ENG-SF19009-R2-FDR_redlines-Summary

# Culvert Report

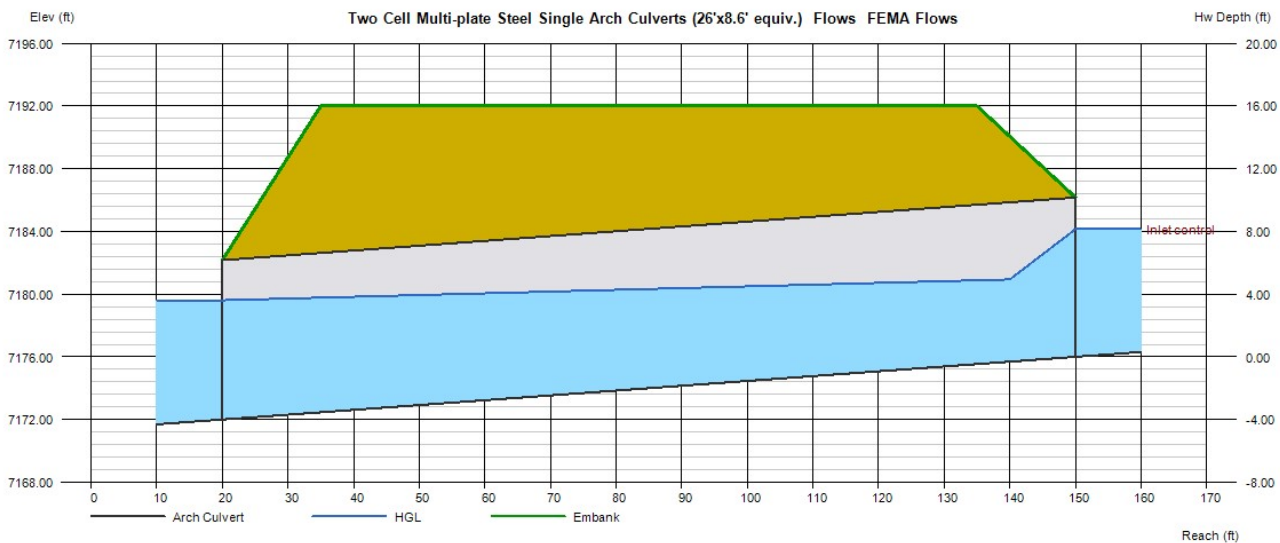
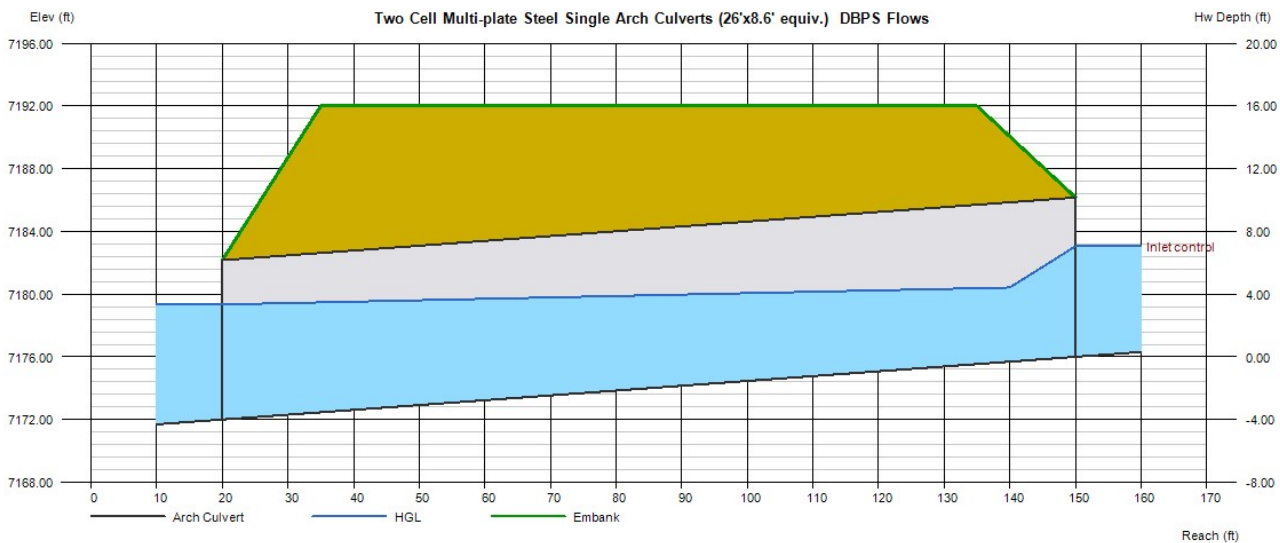
multi-plate steel

verify

galvanized coating (ting will provide) furt and abrasion req
